Hamann Detached Accessory Permanent Occupancy, AL-20-15

Please accept the following comments from El Paso County Public Health (EPCPH) for the project referenced above:

SITE PLAN

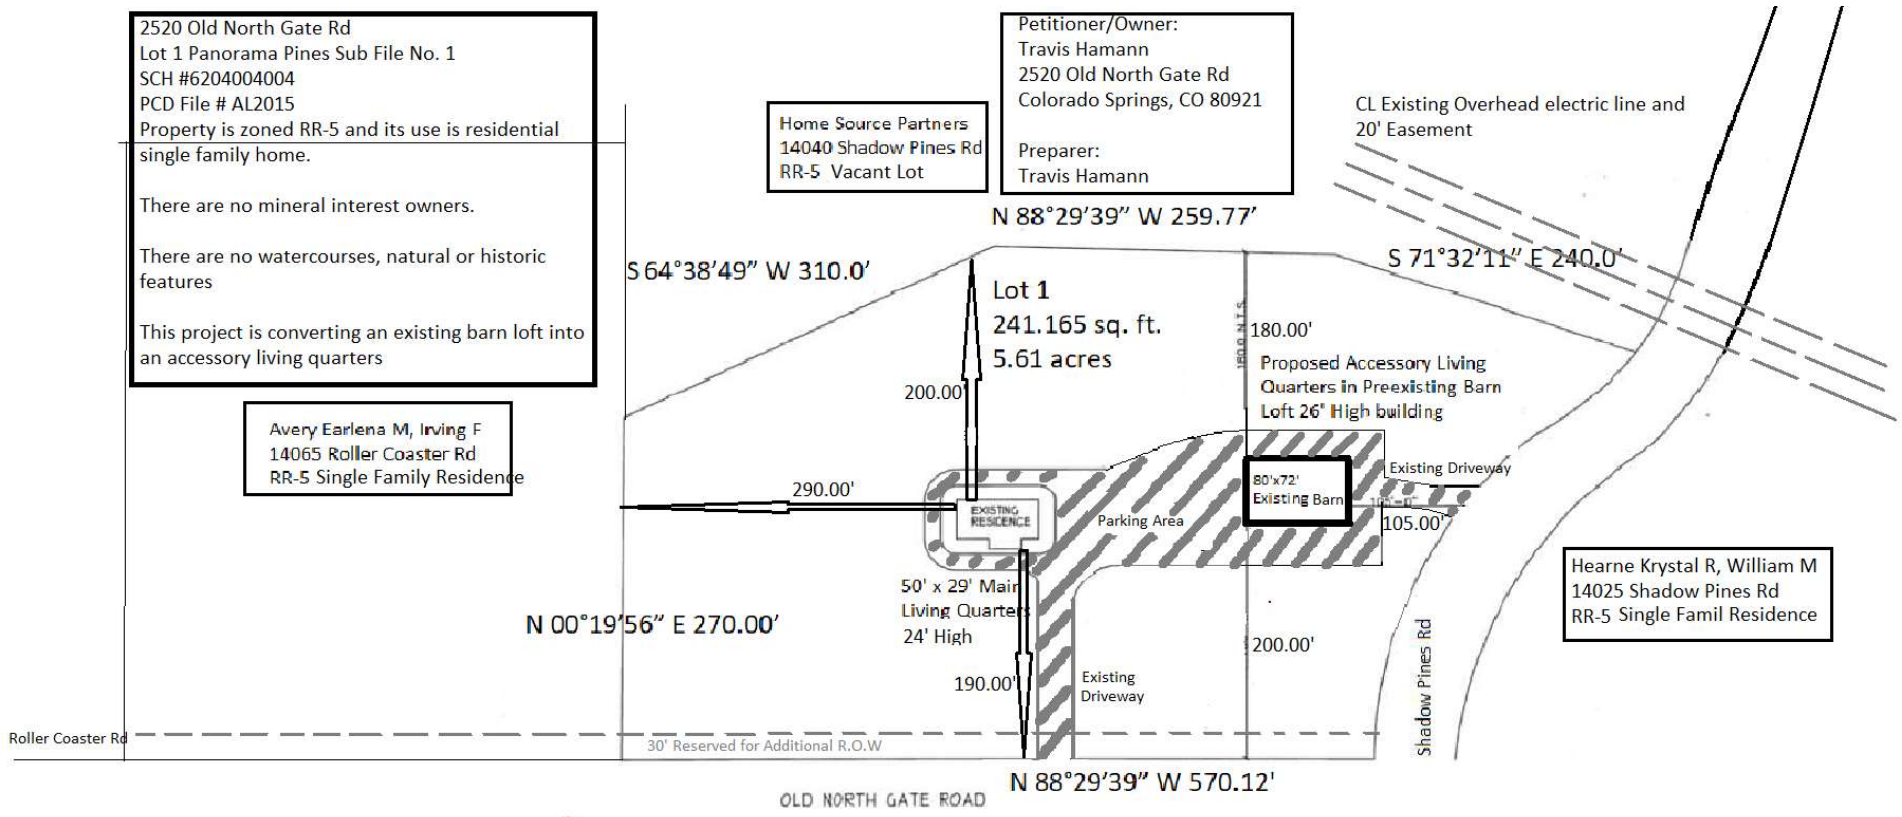
- Connecting the converted loft in the detached barn to the existing septic tank (or to the building sewer line between the house and the septic tank) serving the house by a licensed OWTS installer. This will require a Minor Repair Permit from EPCPH. This is provided the existing OWTS can pass a soil treatment area performance test completed by an OWTS Certified Inspector.

- Installing a new OWTS specifically for the converted barn loft. In this case, all OWTS Regulations must be complied with for a new OWTS.
- The existing water line must meet the setback to the wastewater line, or the wastewater line must be properly encased as specified in the OWTS Regulations.
